## **Application by Highways England for an Order Granting Development Consent for A57 Link Roads**

### **Deadline 5 - response on behalf of High Peak Borough Council**

Responses from High Peak Borough Council are provided in blue to outstanding matters discussed in the hearing session held during the week commencing 7<sup>th</sup> February 2022 in relation to noise and vibration.

**6.4 Environmental Statement  
Figure 11.1 - Baseline Noise Information –  
Daytime**

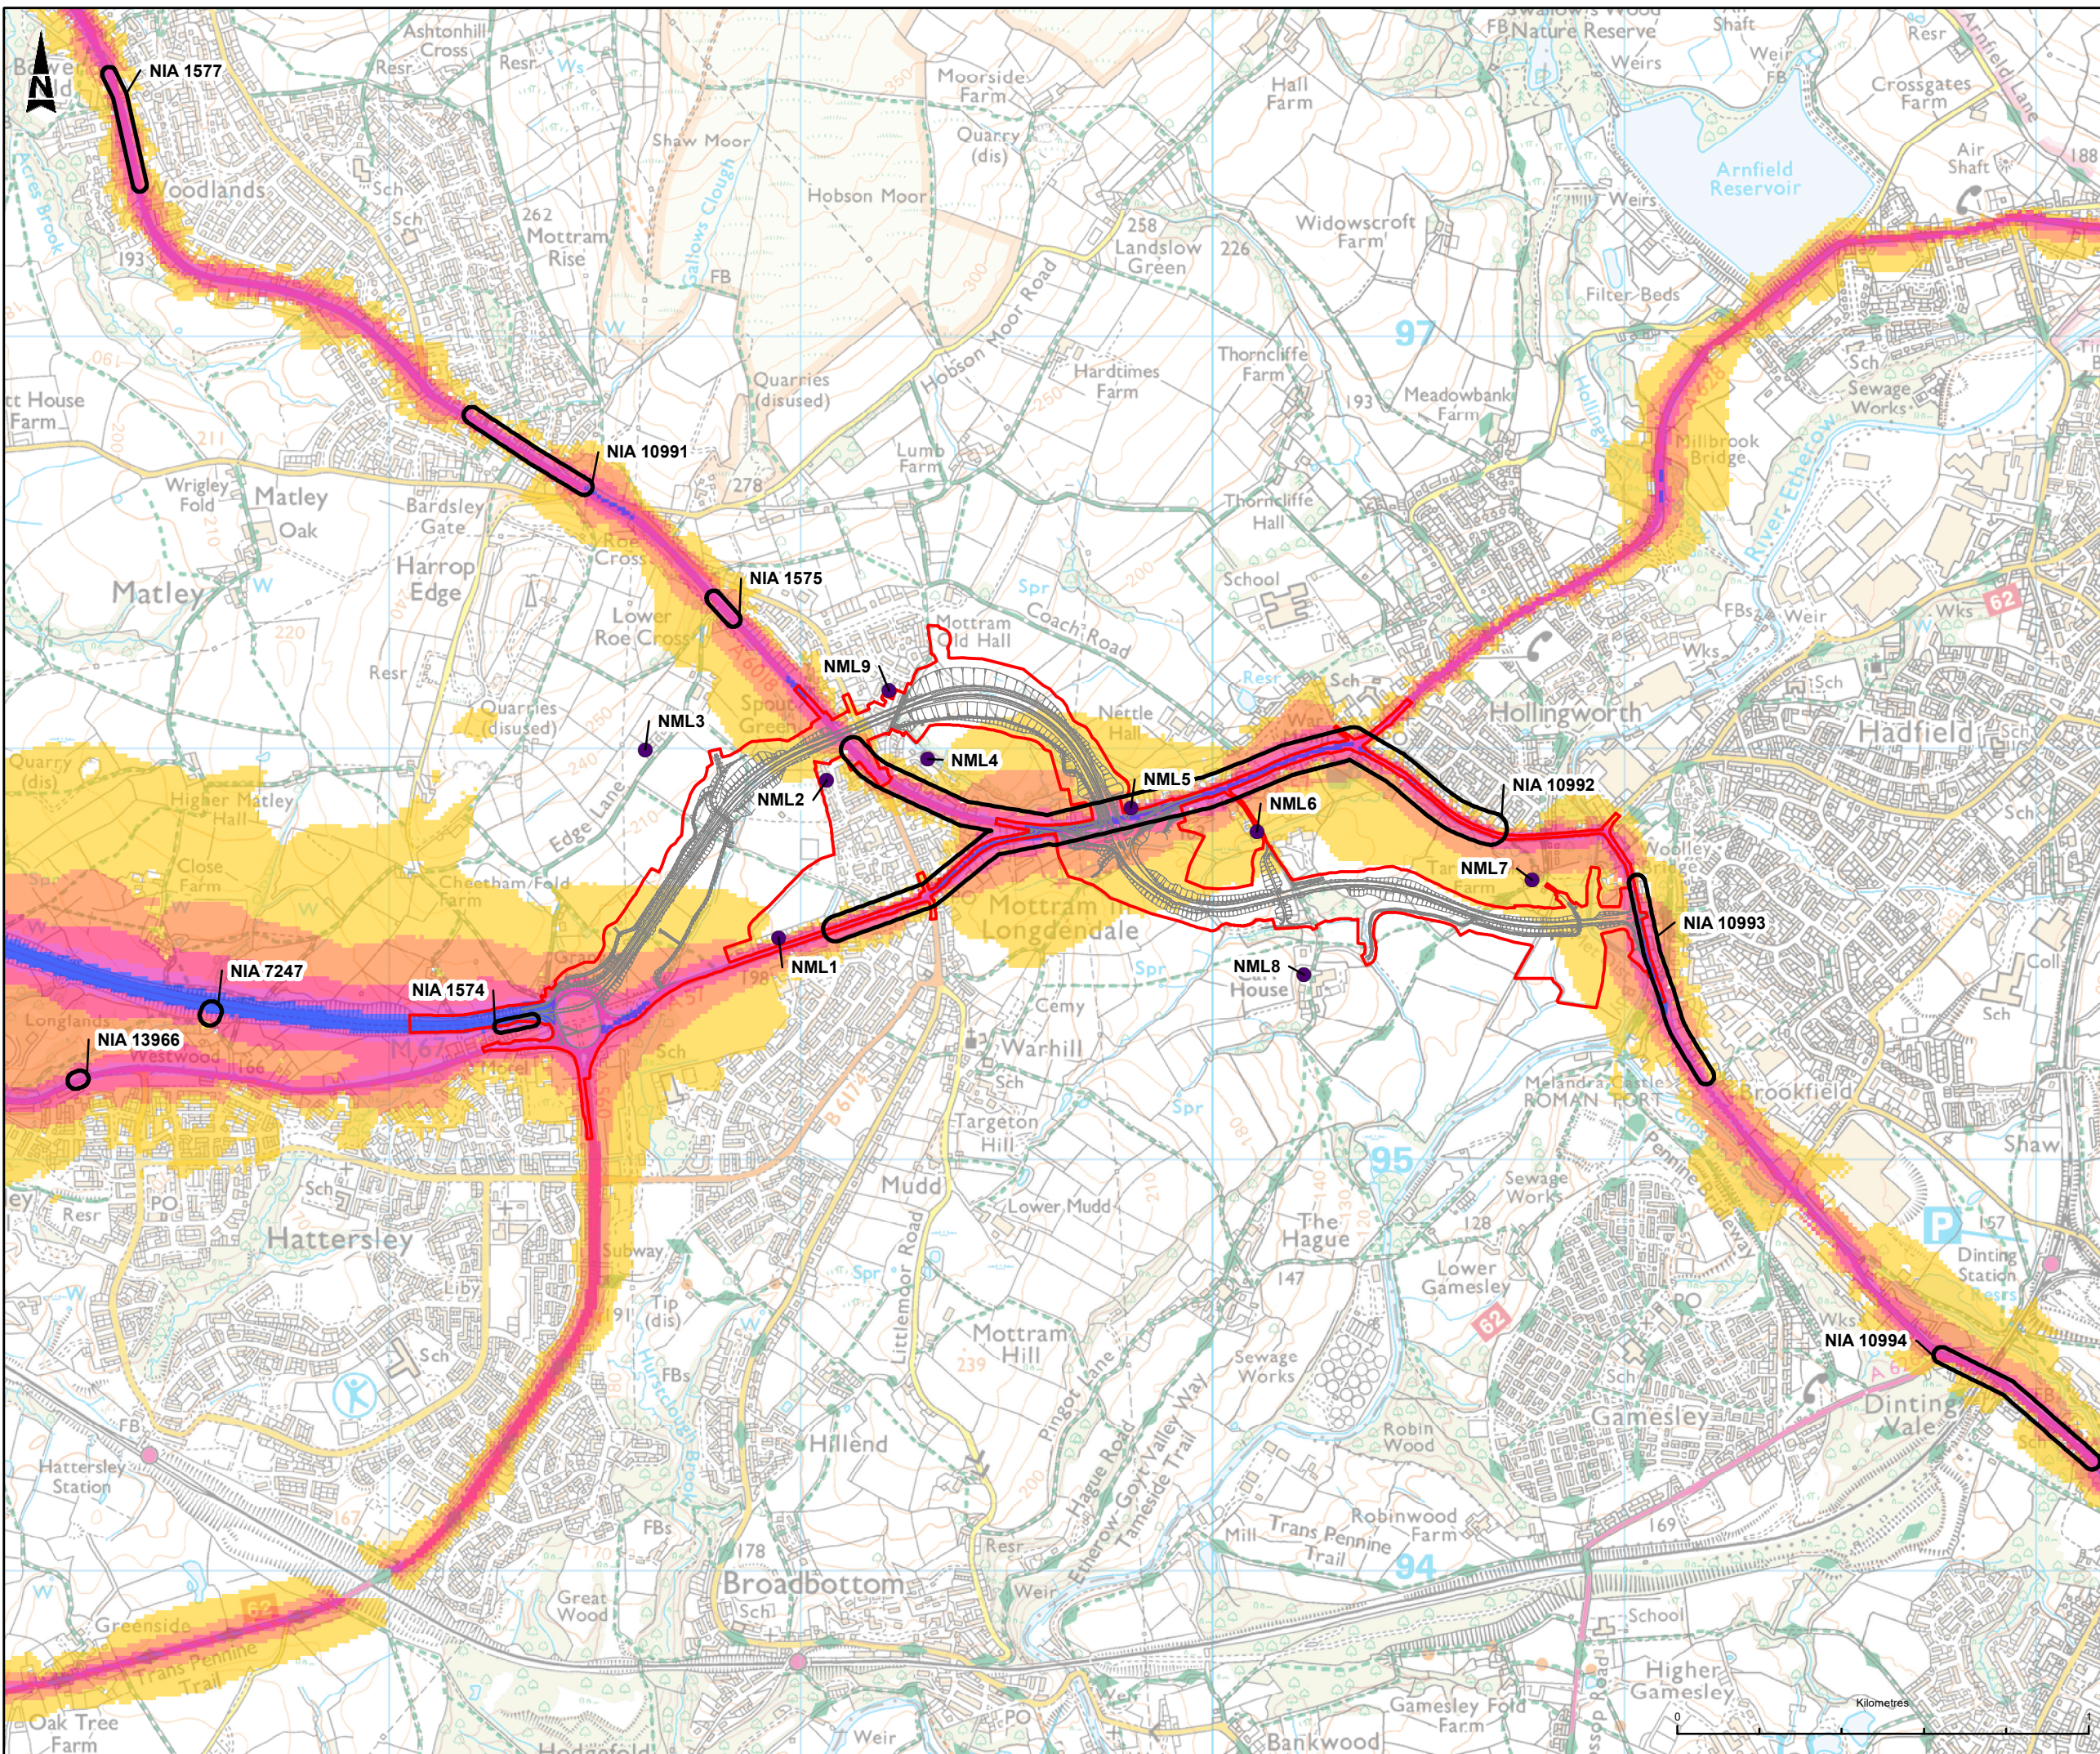
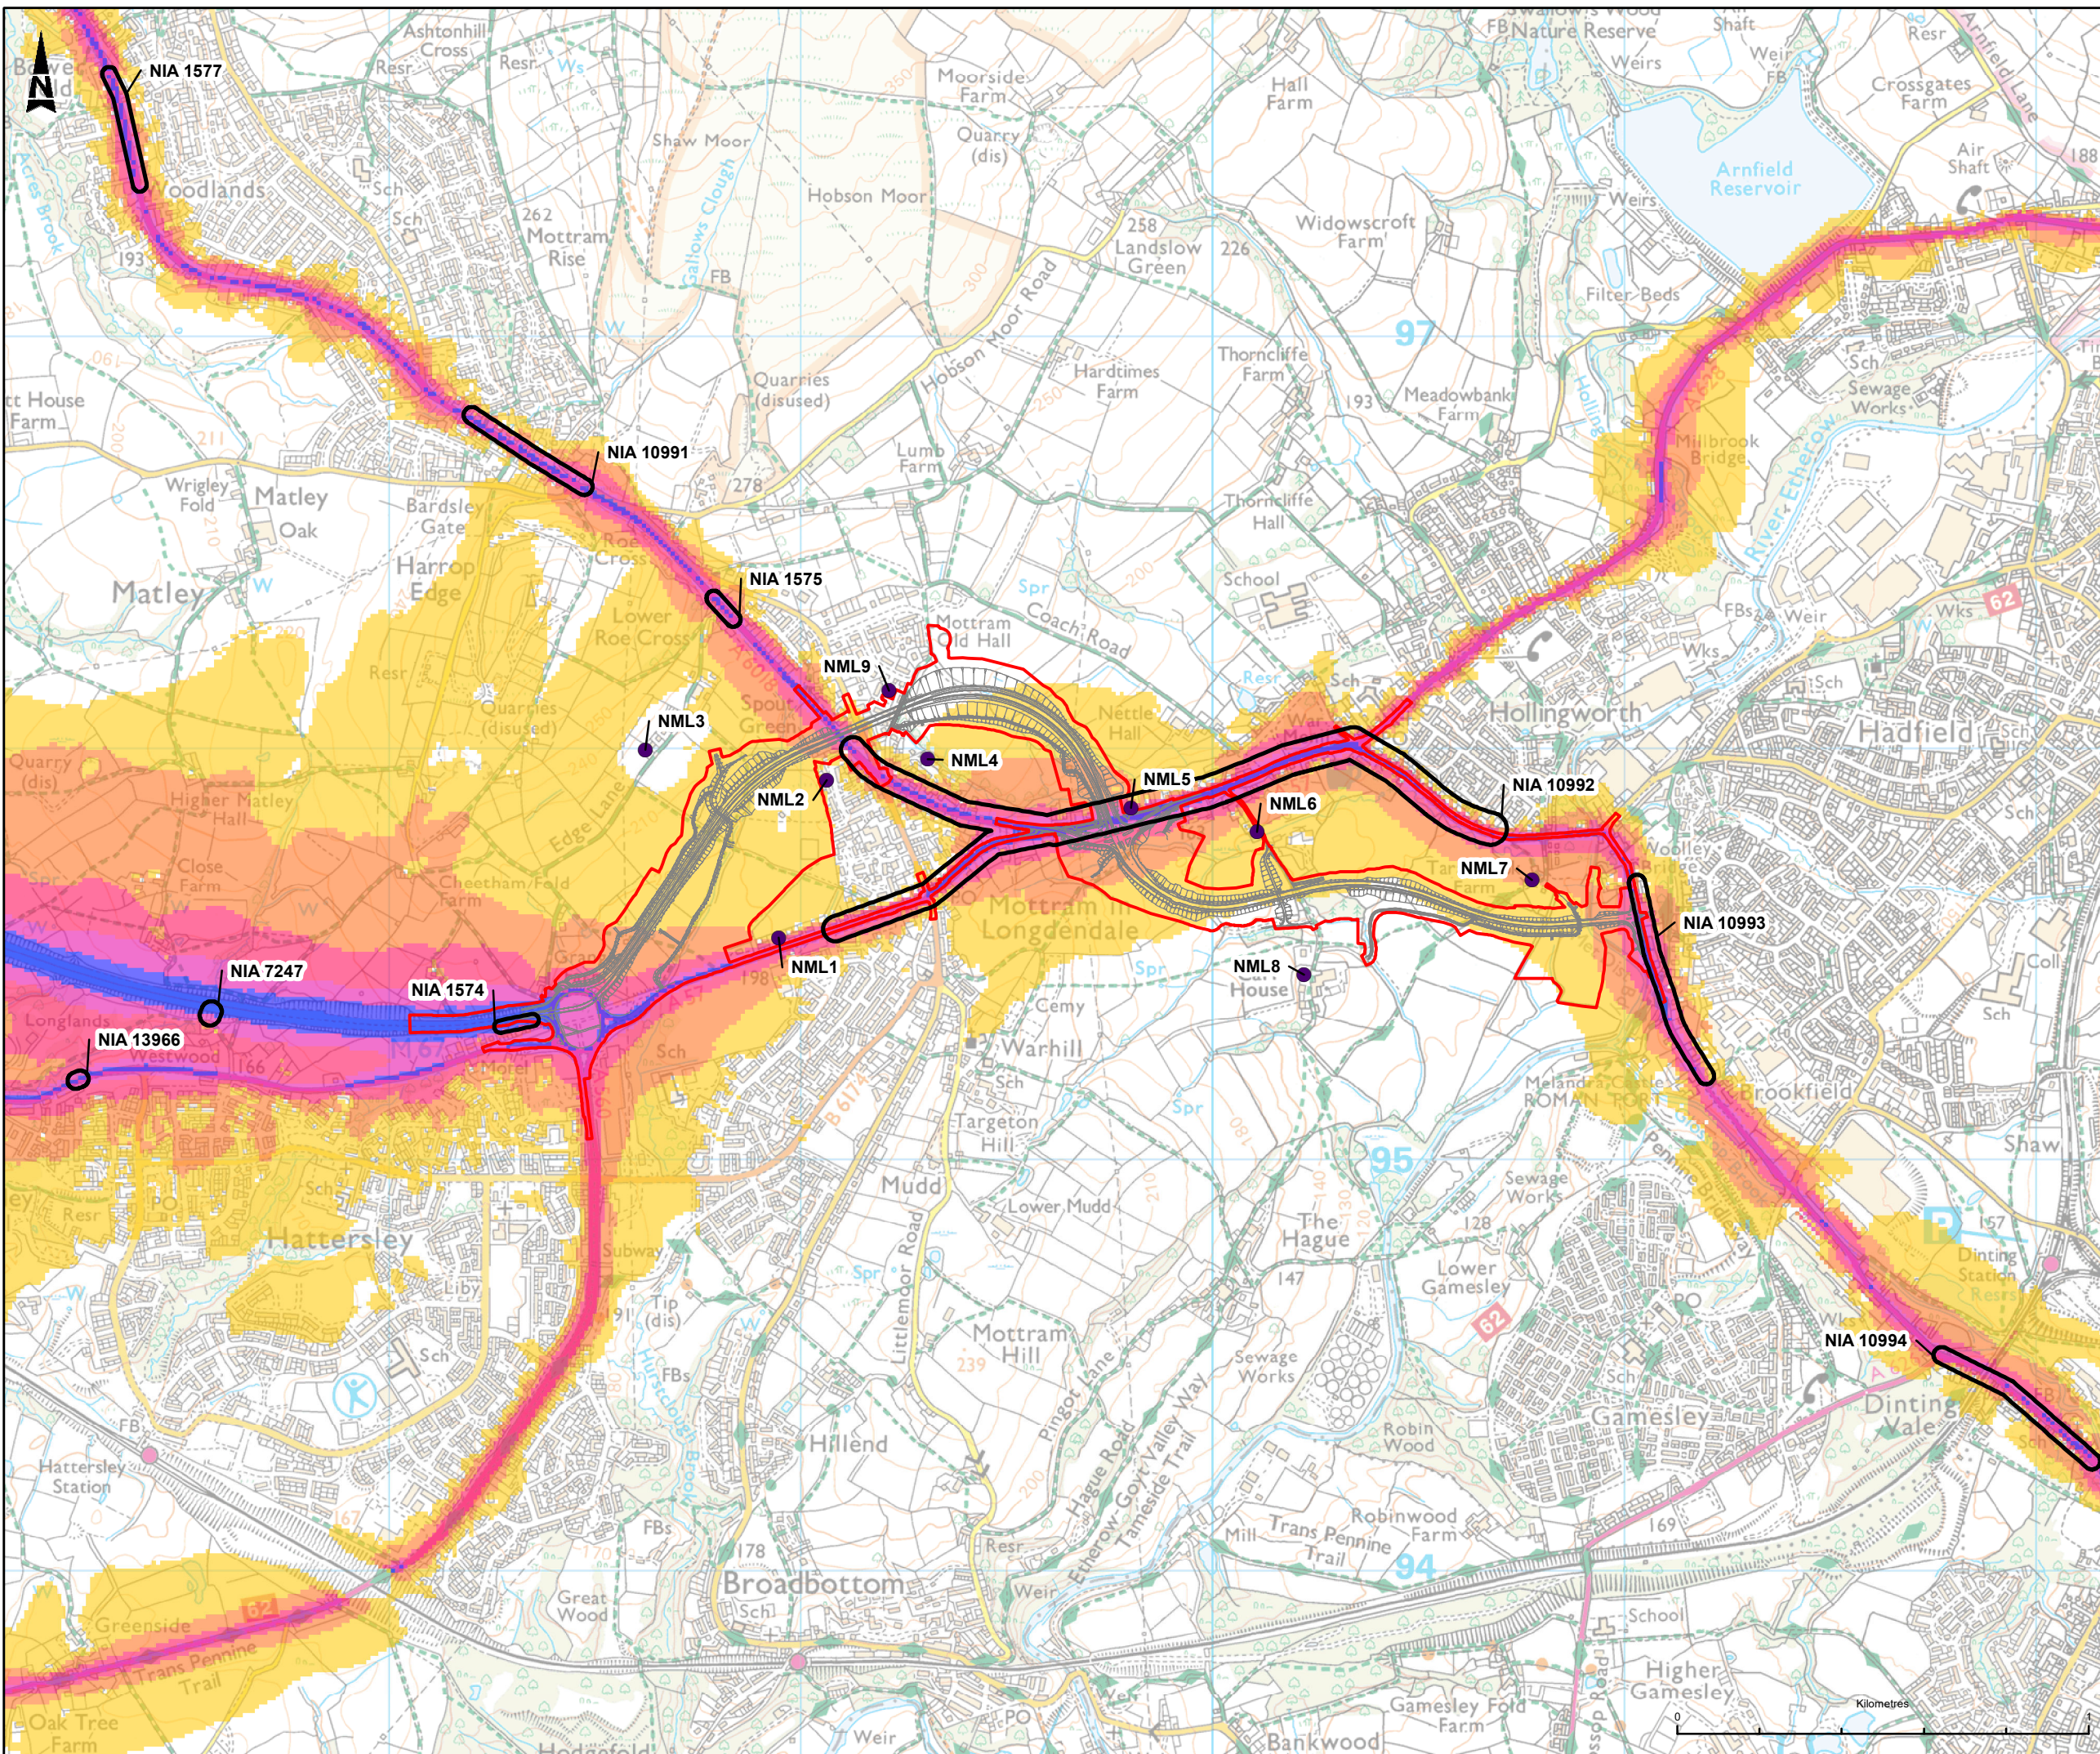
Not significant. In response to the previous request that further monitoring should be undertaken to confirm existing baseline noise levels as part of the EMP for the scheme (to ensure that sensitive receptors in the HPBC area are correctly assigned construction noise limit values).

The applicant has stated that Noise monitoring will be undertaken “in the area of 18 and 54 Wooley Bridge” that is representative of these properties.

This is welcomed, but lacks detail at this stage. the EMP e.g Annex B2: Noise and Vibration Management Plan 2.6.3 notes “Woolley Bridge”
